KITTTITAS COUNTY COMMUNITY DEVELOPMENT SERVICES

RE: *BL-14-00008 Kuchin, Additional Information Request*

# KUCHIN PROPERTY

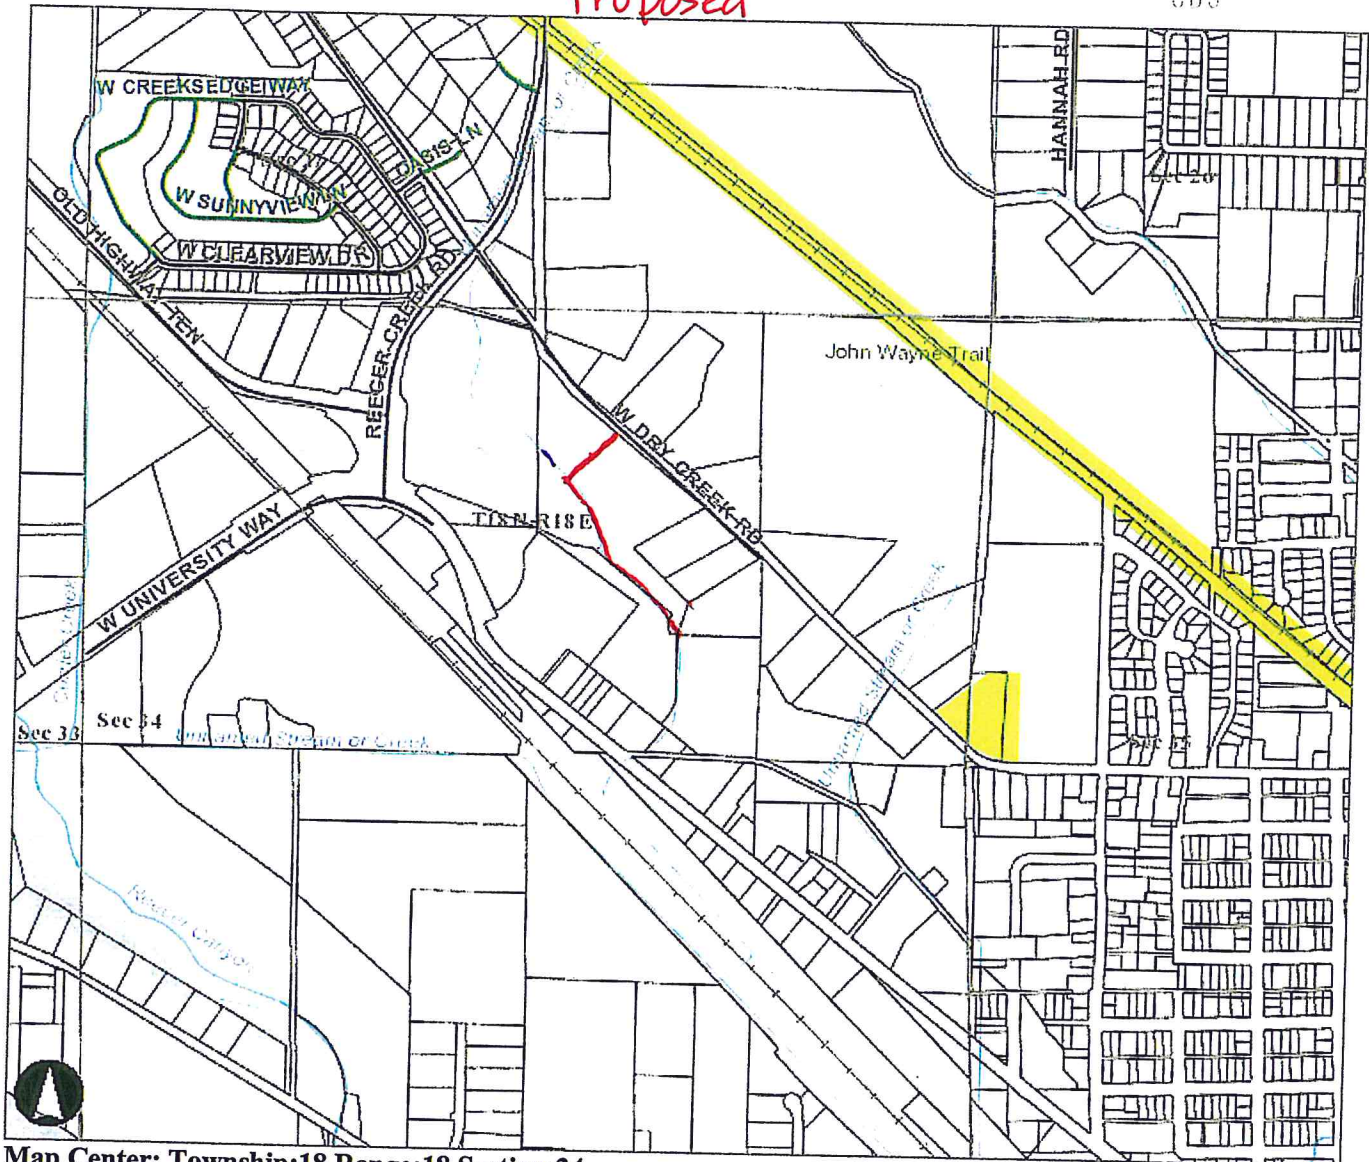
- *Kittitas County Environmental Health has required a site plan indicating where all existing wells and septic systems/ drain fields are on all properties associated with the boundary line adjustment.*
